# CITY OF ALBUQUERQUE

October 17, 2024

**RE: Sigma Chi Apartments  
1815 Sigma Chi Road NE  
Grading and Drainage Plan  
Engineer's Stamp Date: 9/19/2024  
Hydrology File: J15D102**

Based upon the information provided in your submittal received 10/08/2024, the Grading & Drainage Plan is not approved for Building Permit. The following comments need to be addressed for approval of the above referenced project:

## GRADING AND DRAINAGE PLAN

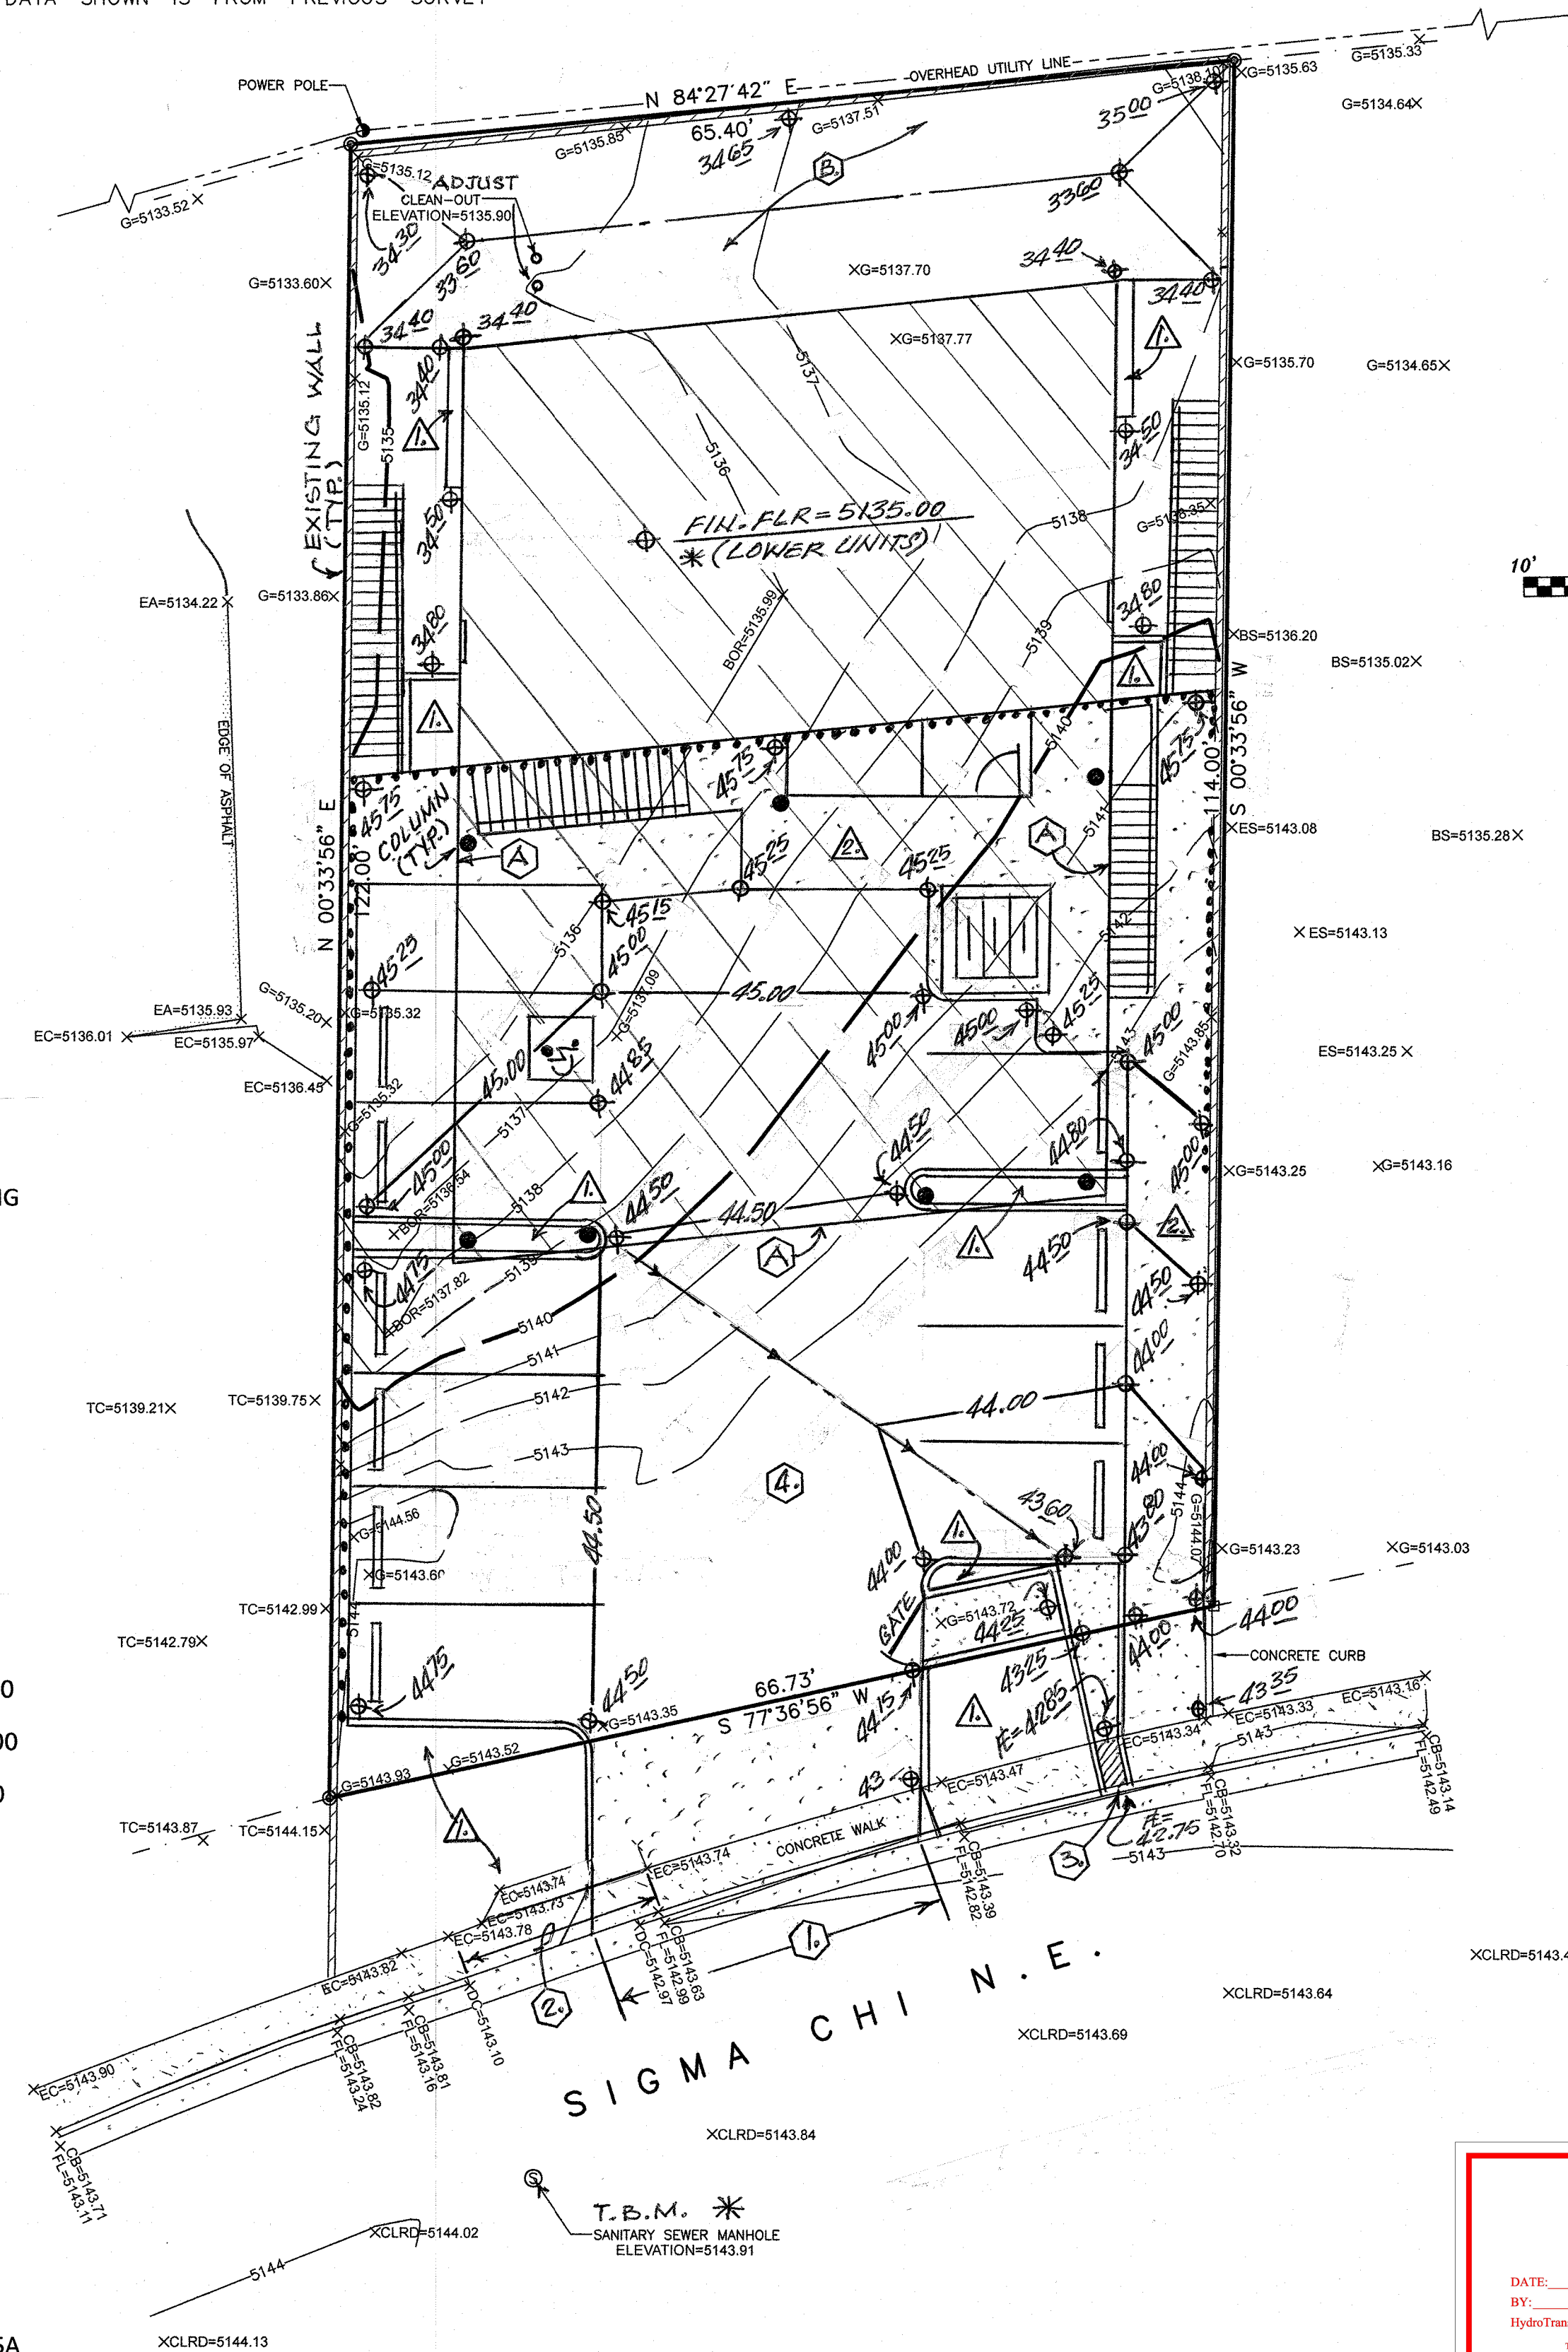
1. Payment in Lieu (Amount =  $142.2\text{CF} \times \$8/\text{CF} = \$1,137.60$ ) of onsite management of the SWQV must be made. Take three copies of the treasury deposit slip to the Treasury and then include one copy of the paid deposit slip when resubmitting.
